## **RE : 2020/91896 – PENTLANDS, NEW MILL ROAD, HOLMFIRTH, HD9 7LN**

I write to you in regards to our planning application (2020/91896) to summarize the alterations and modifications ourselves, and our consultants have made to the proposals following your email discussing your concerns over the application on the 11<sup>th</sup> of August 2020.

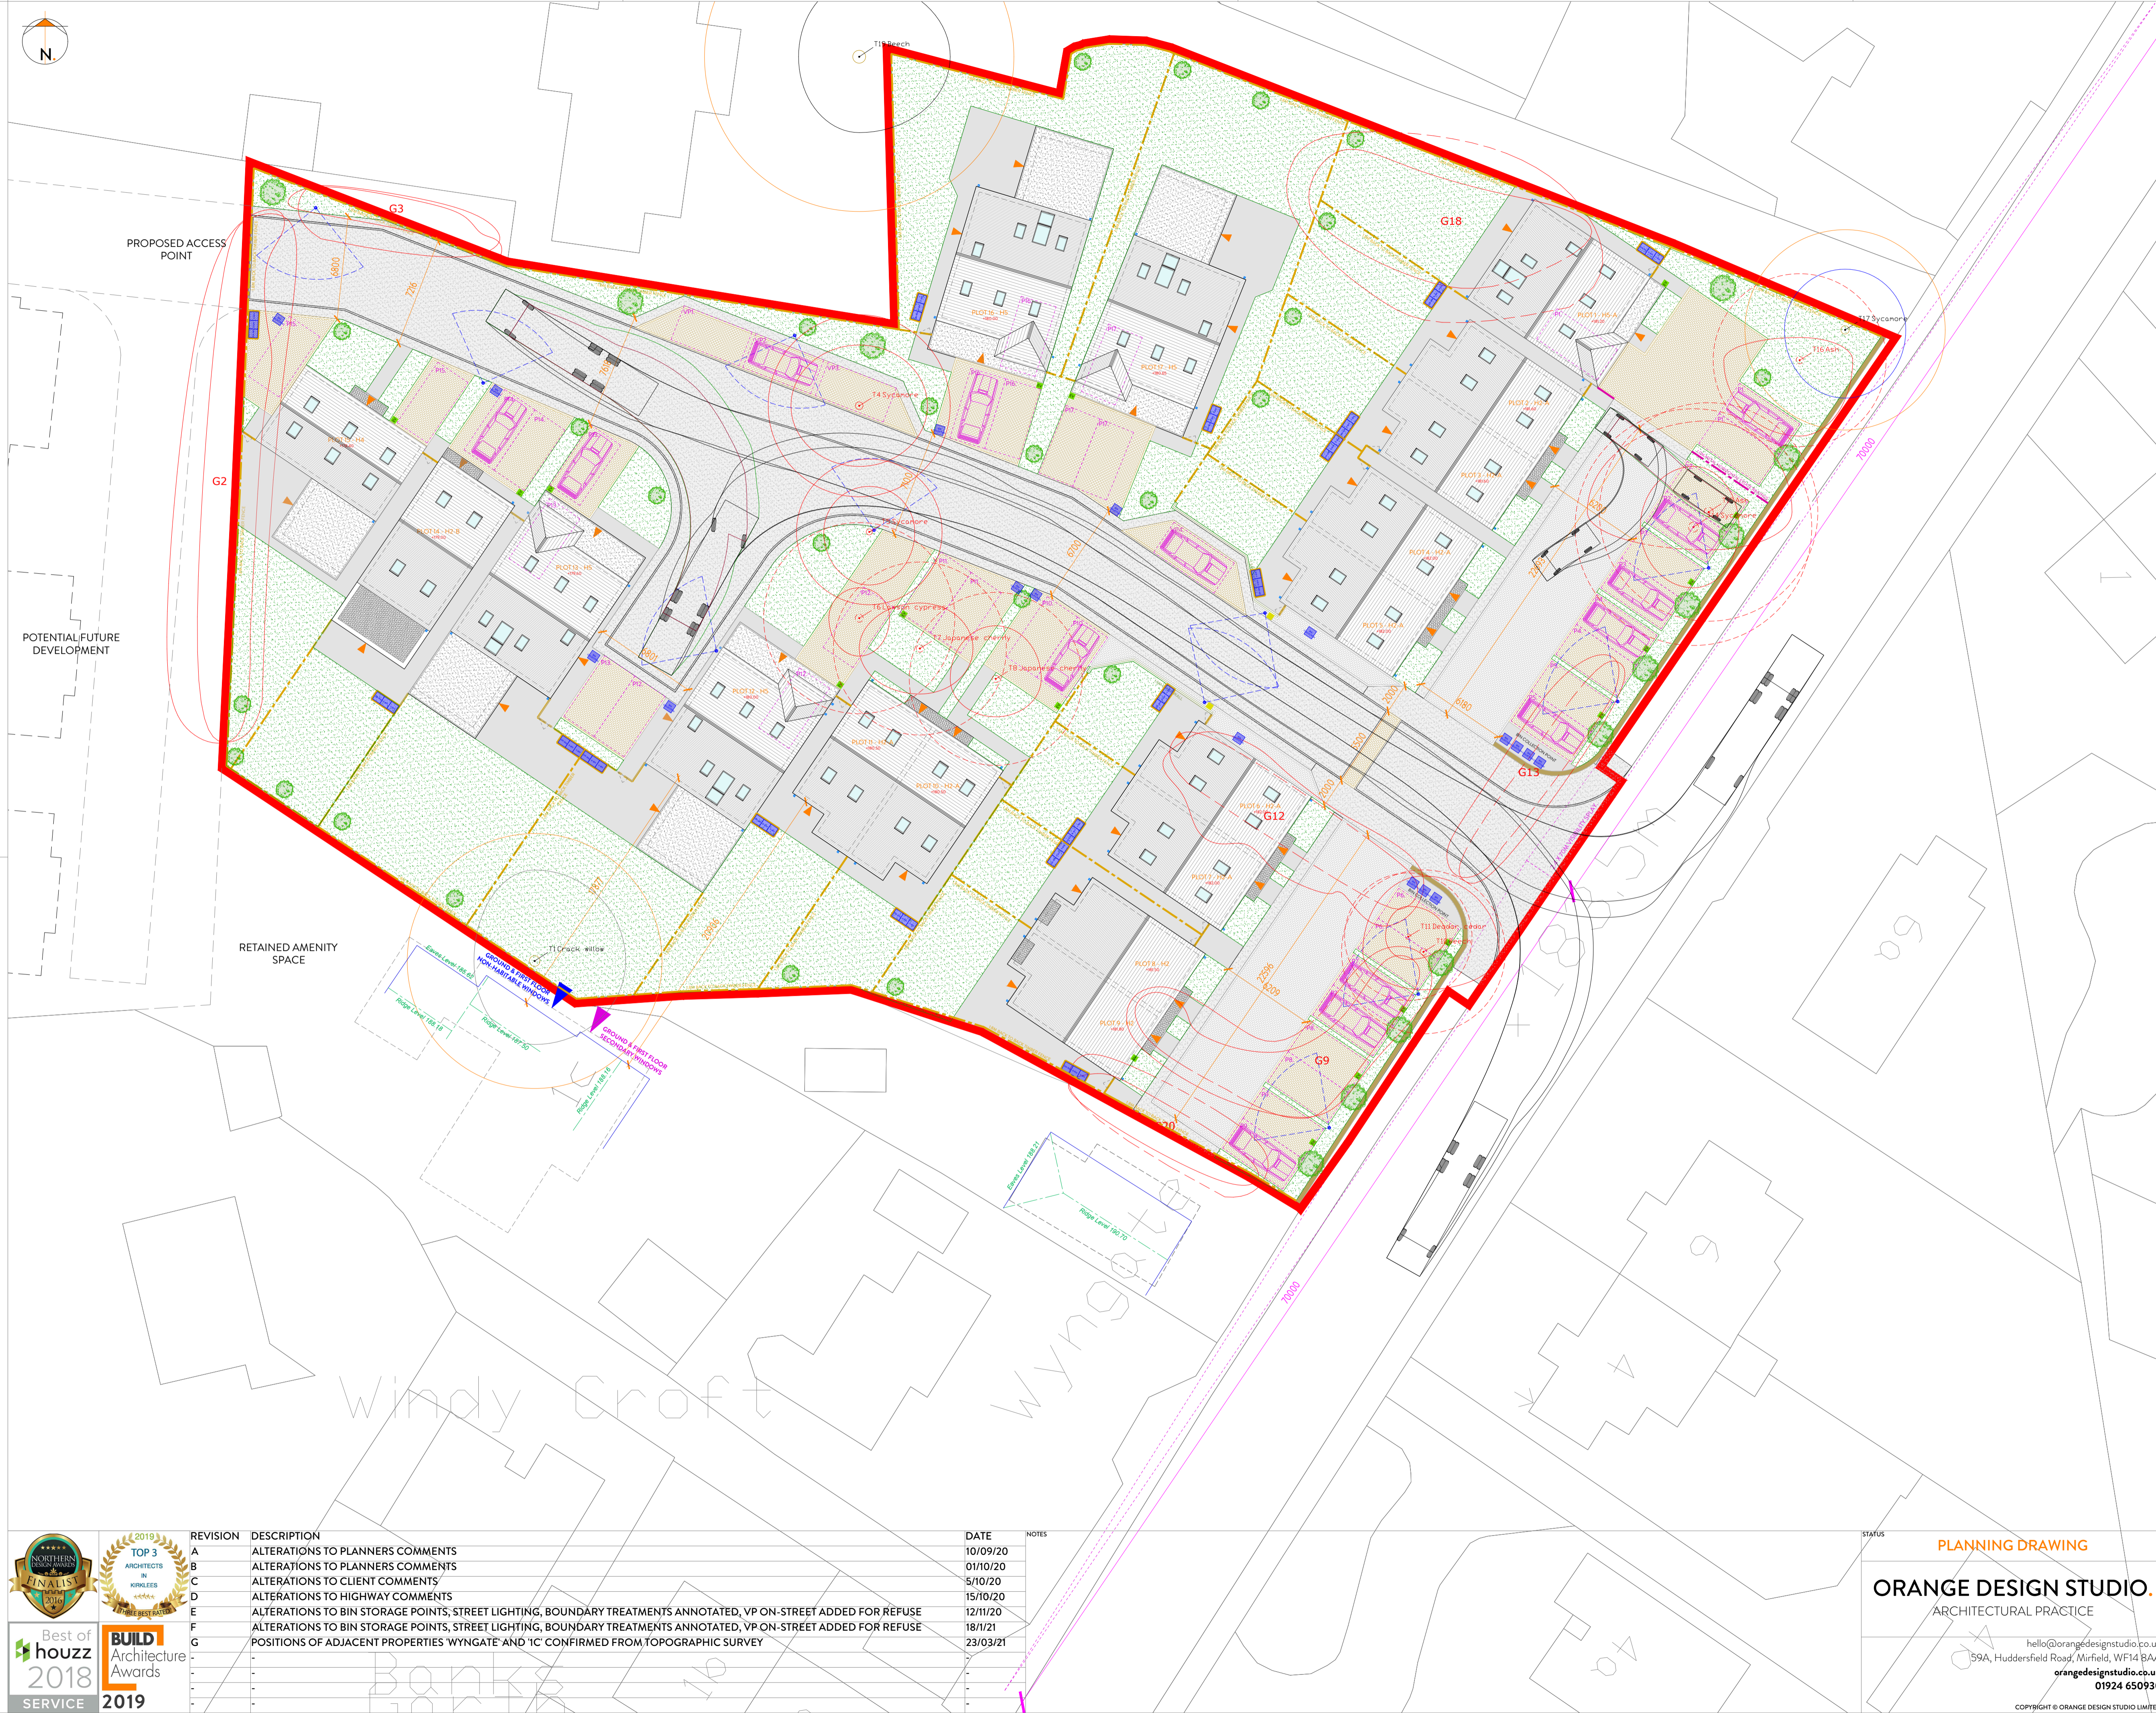
*The proposed residential layout would result in part of the residential site allocation HS189 not being able to be developed. Within the supporting statement, reference is made to the adjacent landowner having no desire to develop their land within the site allocation. However, this does not rule out the possibility that the concerned landowner/s or a potential future purchaser may wish to develop this area of land in the future. More importantly, your proposed justification does not support a departure from Local Plan policy LP5.*

*Officers consider that the proposed density of 48 dwellings per hectare would represent 'overdevelopment' and would result in adverse impacts on residential and visual amenity. The street scenes would be dominated by the parked car, with minimal soft landscape features, and no public open space for biodiversity enhancement or visual amenity. Also, there are no bin presentation points. Officers consider that the proposal would result in a residential character with a 'central urban feel' rather than a more 'spacious suburban/rural feel.' As outlined in the pre-application enquiry letter and Planning Policy response a density of around 35 dwelling per hectare would be preferred, taking into consideration site constraints, i.e. mining features, trees,*

*etc. Officers also have serious concern about the proposed relationship between the proposed development and with the existing properties known as Wynncliffe, 1C and Glenn View.*

*The above design matters seem to have been overlooked with the latest design proposal. In particular, the proposed development would result in plots 1 to 14 turning their back onto New Mill Road which would mean these properties would not face the most important area of public realm that they abut, contrary to good design practice (see paragraph 68 of the National Design Guide) and Local Plan policy LP24 criterion e. I suggest that the proposed private access roads/driveways be relocated adjacent to New Mill Road and that the dwelling houses be redesigned to front onto this road.*

*A boundary treatment schedule has not been provided. This should be provided to enable officers to assess all visual and amenity impacts of the proposed development holistically.*

*To protect residential amenity a separation distance of 21 meters is required between existing dwelling 1c and the habitable room windows of plots 21 and 22. It appears that a separation distance of only 18 meters has been proposed.*

*Concern is expressed about the proposed relationship between plot 17 and Glenn View which has now only a separation distance of between 16m-17m. Furthermore, a greater separation distance is also required between plot 18 and Glenn View to ensure that the existing residential amenity is truly respected.*

Our proposals have been amended and redesigned to take into account these comments. In line with policy LP5, we have provided access provision within our proposals as well as demonstrating how the remaining land of the allocation H189 could be developed alongside our proposals. As well as this we have also demonstrated internal turning provisions and forward visibility for this proposed access point.

Our development unit numbers have been reduced from 25 dwellings to 21 dwellings which reduces our site density to 38 dwellings per hectare with our site area been 0.56HA. As well as the reduction to density numbers, we have utilized the increased open spaces to increase soft landscaping areas and opted for parking to the side of dwellings where possible which as a result reduces hard landscaping areas. The proposed site plan also now clearly demonstrates bin storage and presentation points, swept path and visibility envelopes.

The latest proposals have plots one to thirteen facing New Mill Road and do not turn their back out of the site in line with the recommendation above.

Proposed boundary treatments are clearly highlighted and annotated in the proposed site plan and key.

Kirklees adopted local plan does not have any space about buildings policy nor are there are minimum distance requirements. Using the outdate and removed BE12 policy for distances in this case would not be appropriate. However, the side first floor facing windows from 1C are not primary habitable windows, they are secondary habitable windows that are screened by a retained mature tree. The windows are Ground floor will be screened by a fence as shown on the proposed site plan and further screened by the aforementioned retained tree. It is of our opinion that The proposals do not affect the residential amenity of 1C.

Kirklees adopted local plan does not have any space about buildings policy nor are there are minimum distance requirements. Using the outdate and removed BE12 policy for distances in this case would not be appropriate. However, we have omitted this house type for a two and a half storey dwelling and increased the separation distance from 16 to 18.5M.
